Reference: **New Primary School in Edmondson Park
Buchan Avenue Edmondson Park NSW 2174**

ACCESS REPORT – SSSA REPORT

**NEW PRIMARY SCHOOL IN EDMONDSON PARK
BUCHAN AVENUE
EDMONDSON PARK NSW 2174**

Drawing No. **AR- W-DW- 2001** Revision **E**

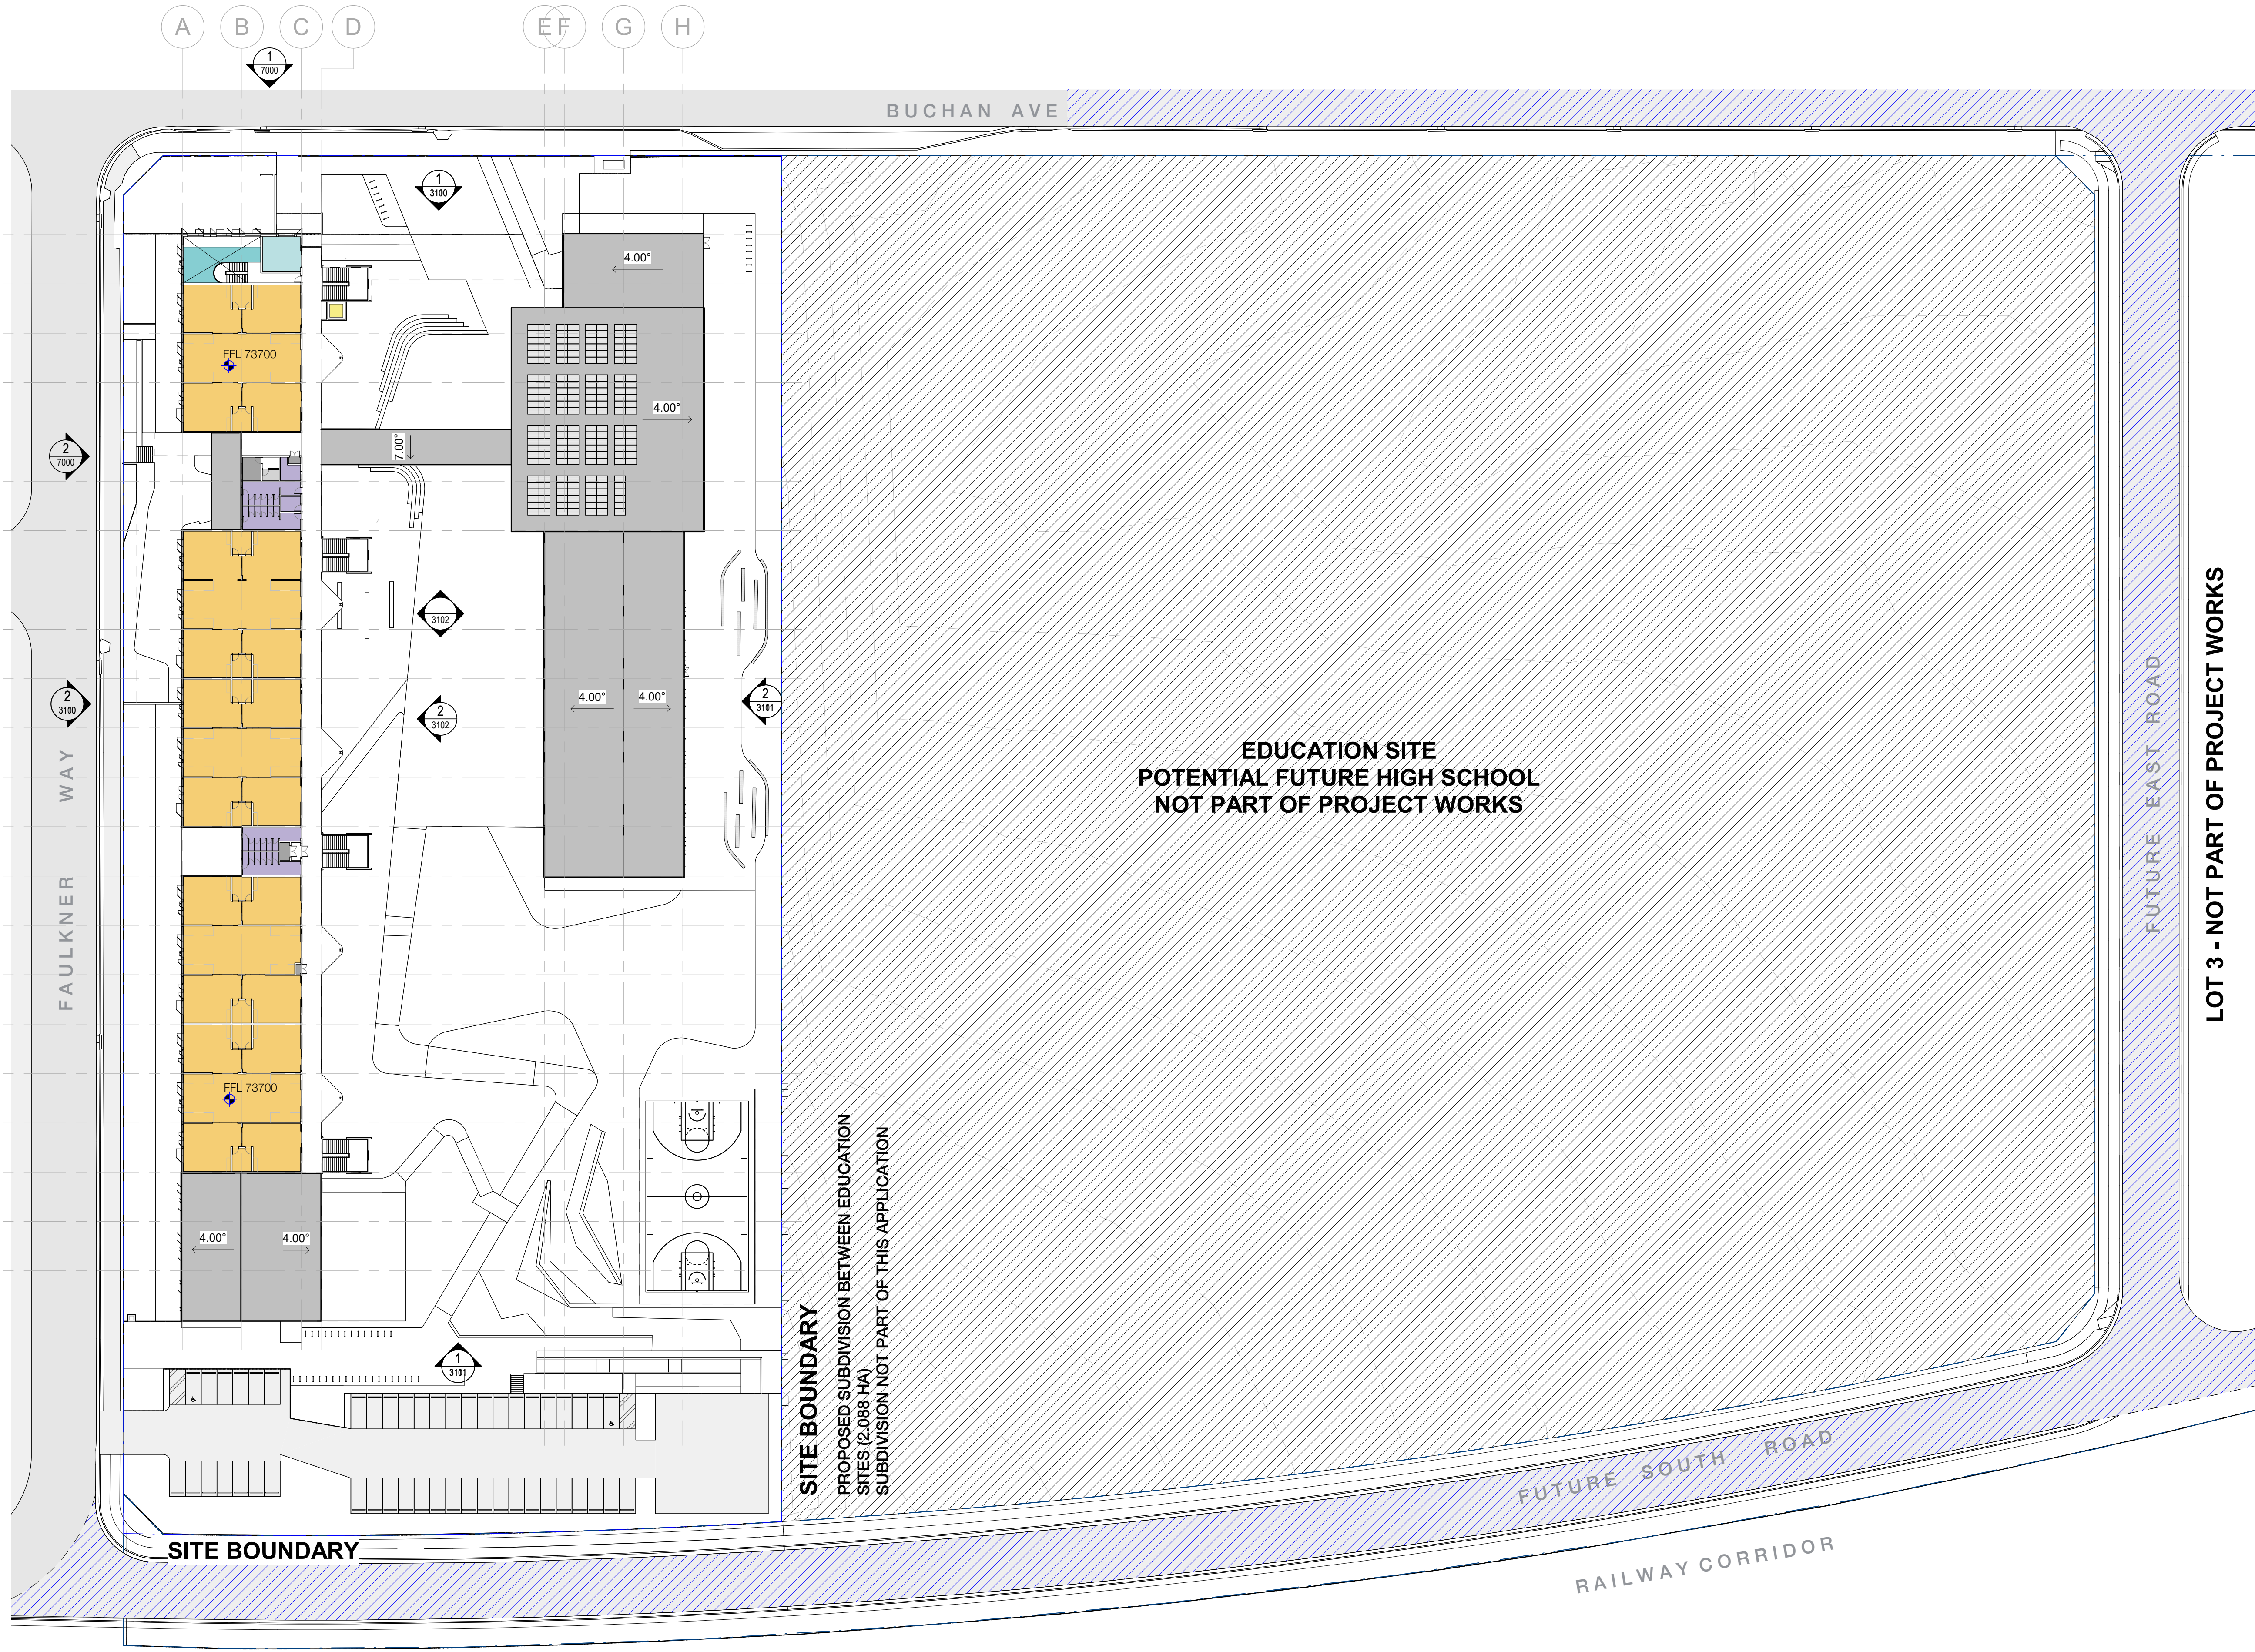
The site has multiple access points. Parking is proposed at grade.

- Main entry from Buchan Avenue
- Secondary entry off Faulkner Way through a switchback 1:20 ramp
- Entry to carpark off Faulkner Way

The site slopes slightly. The landscape design will need to detail an accessible path of travel at ground level which will allow students with accessible needs to access the various areas of the playground.

Special attention is directed to the length of 1:20 walkways and the detailing required for walkways.

Compliance: Future documentation will need to be provided indicating the paths of travel within the playground areas.
